September 21, 2009

RE: Vance project, 355 Warren Avenue (Tow Lot)
Minor Site Plan (maximum of 70 vehicles to be stored)
Application ID # 2007-0138

TO: Jean Fraser
FROM: Dan Goyette, PE
DATE: November 13, 2008
RE: 355 Warren Avenue

Boundary Name and Location  
**BOUNDARY SURVEY/EXISTING CONDITIONS**  
 355 WARREN AVENUE, PORTLAND, MAINE

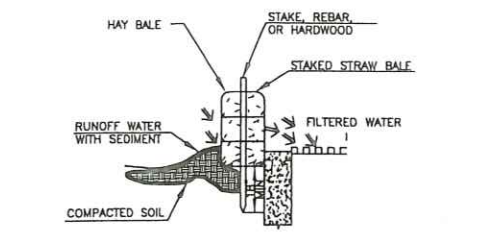
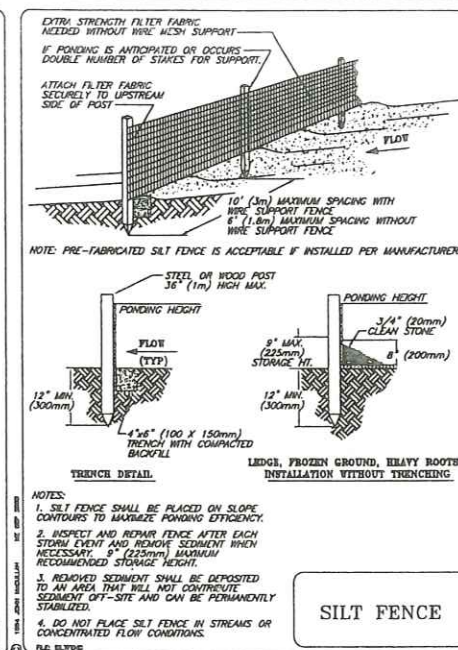
1. Please address the attached engineering review comments dated November 13, 2008. A complete boundary survey is necessary as no waiver has been granted regarding the survey. Please see our letter dated September 15, 2008, which was confirmed at the meeting with Mr Jaegerman on September 29, 2008;
2. The plans need to specify the size and species of the planting; Jeff Tarling, City Arborist would be willing to advise on this (he can be contacted on 874 8462 or JST@portlandmaine.gov).

- The applicant should confirm that the survey for the project coincides with approved City standards. The applicant states that this requirement has been waived but we are not aware of any such agreement. If there is not an agreement, the survey needs to be tied to the vertical datum of NGVD 1929. Also, the project needs to be tied to the Maine State Plane Coordinate System (2-zone projection), West Zone using the NAD 1983 (HARN) Datum and the U.S. Survey Foot as the unit of measure. This should be indicated on the survey.
- Erosion Control Measures have not provided.
- The manhole detail shows only RCP while the plans show ADS N12 pipe. ADS N12 pipe is not allowed within the City Right-of-Way.

**SITE PLAN**

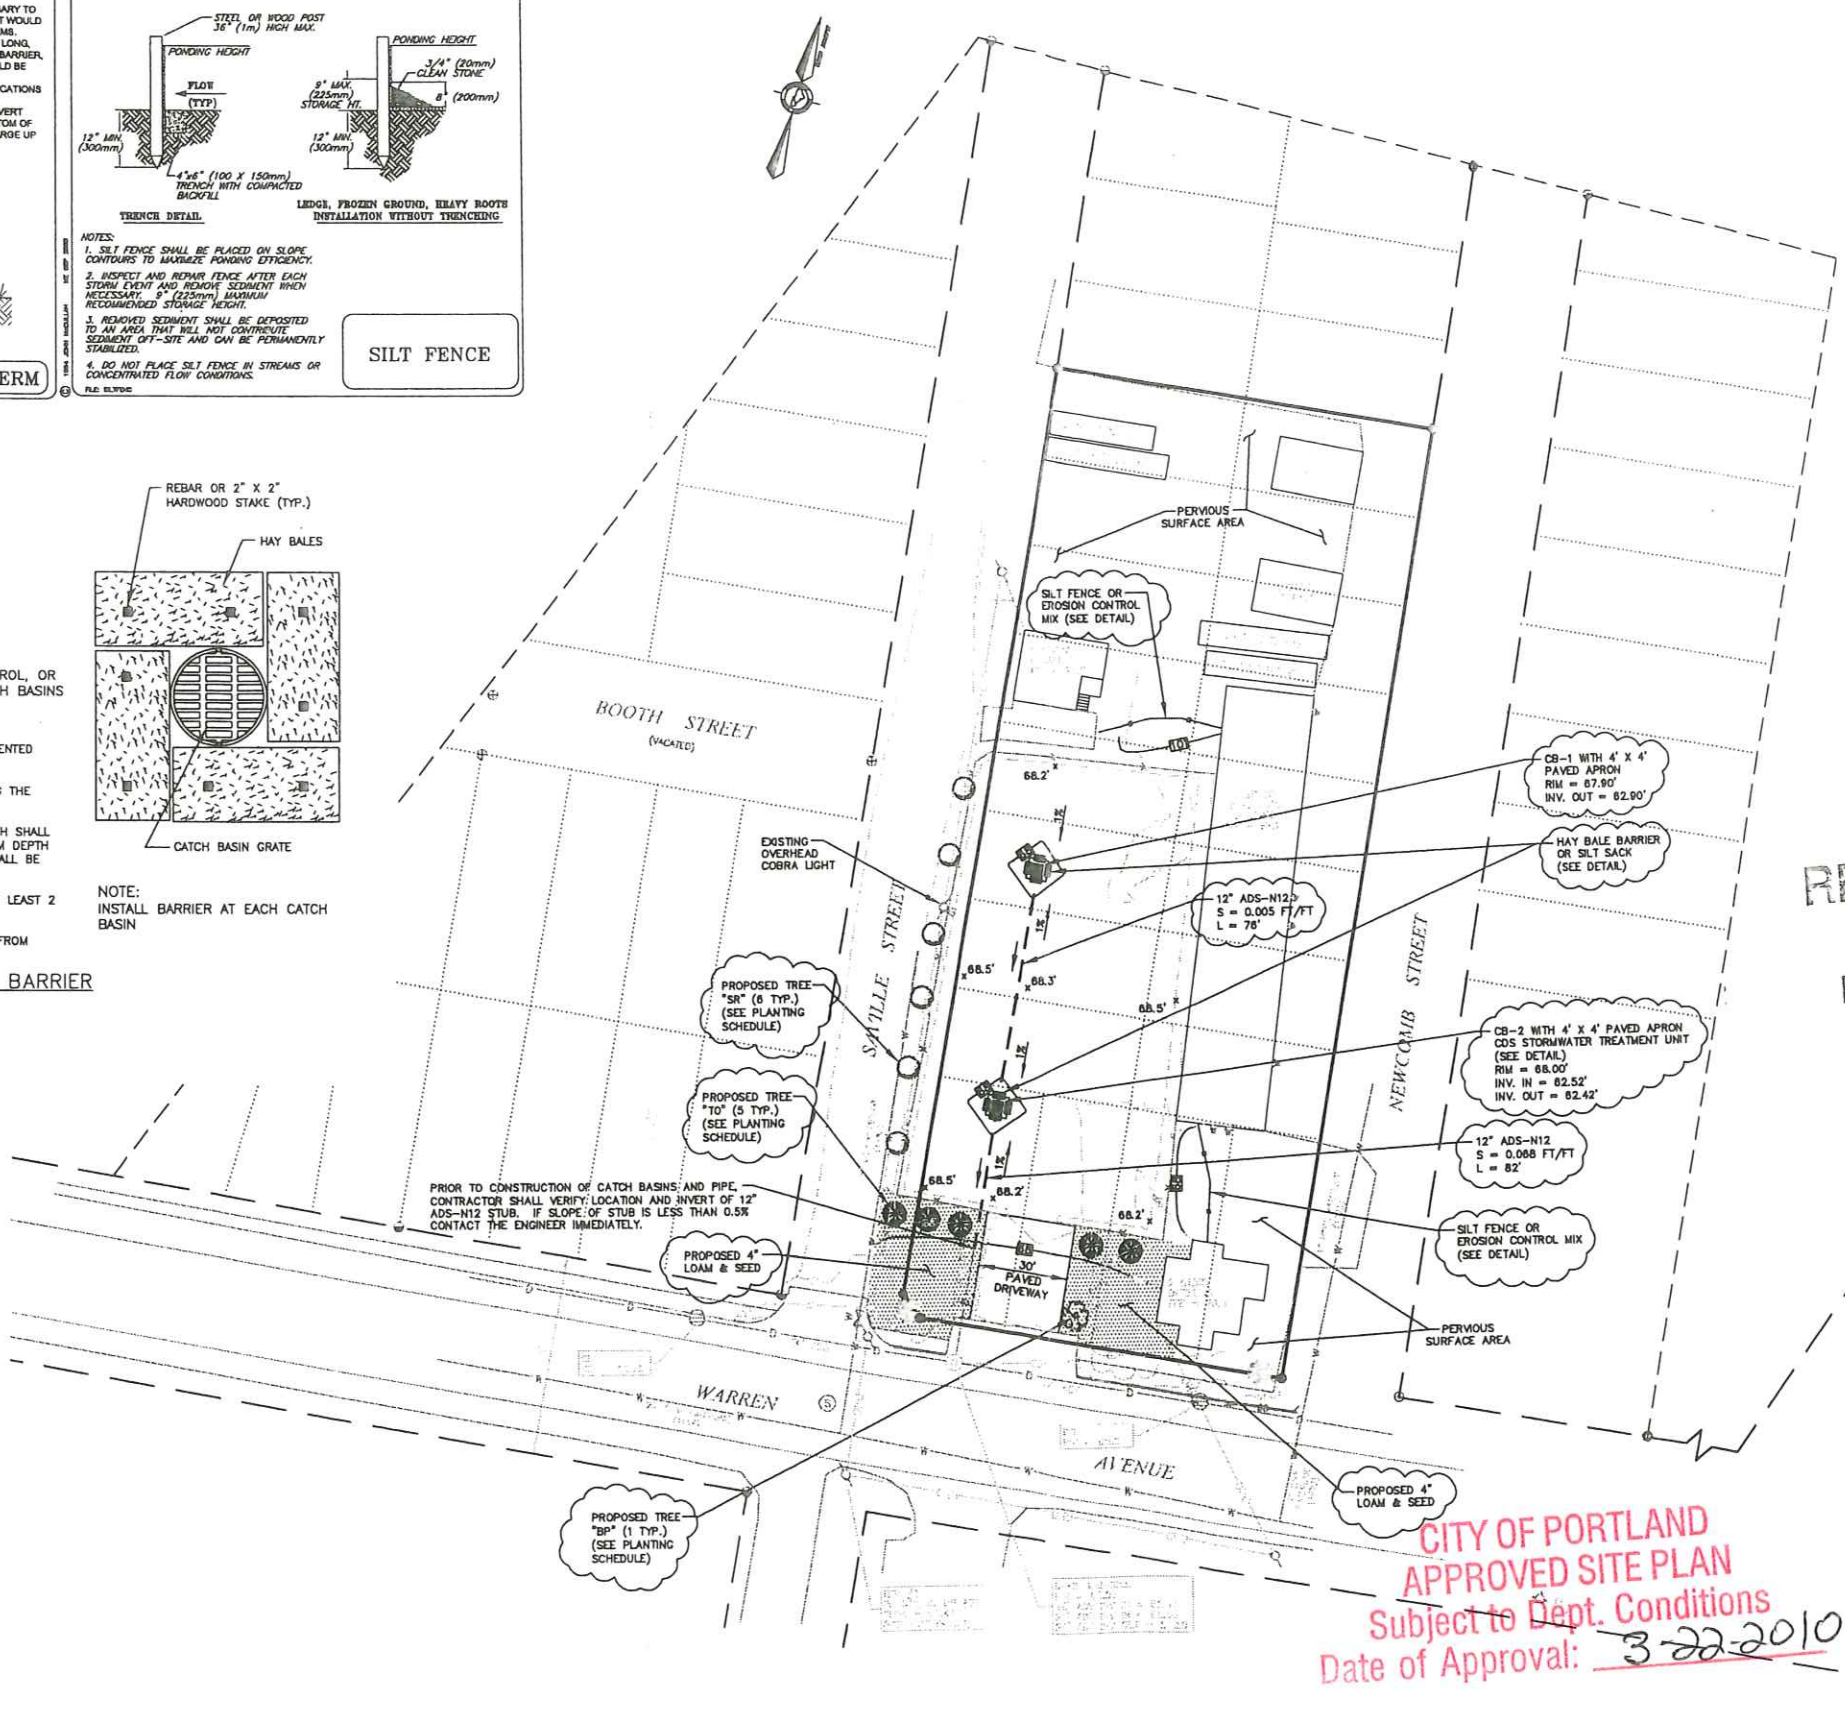
Also at that time we agreed that the curb cut would be 30 feet wide and centered on the existing access to the tow lot, with the area between the ROW and the tow lot improved with plantings by Mr Vance, as set out in your letter to the MDOT dated November 3, 2008 (copy attached).

1. Satisfactorily address the 2008 review comments;
2. Reflect the agreed proposals relating to the ROW;
3. Address the question of the condition of the existing fencing, as mentioned in our letter of September 15, 2008 (see attached photograph); the improvements to the enclosure should be integrated with the final planting and sidewalk proposals; and
4. (Optional) Add in any amendment(s) that relate to the MDOT project that are located along the tow lot frontage within the site boundary eg demolition of the building addition and re-cladding.
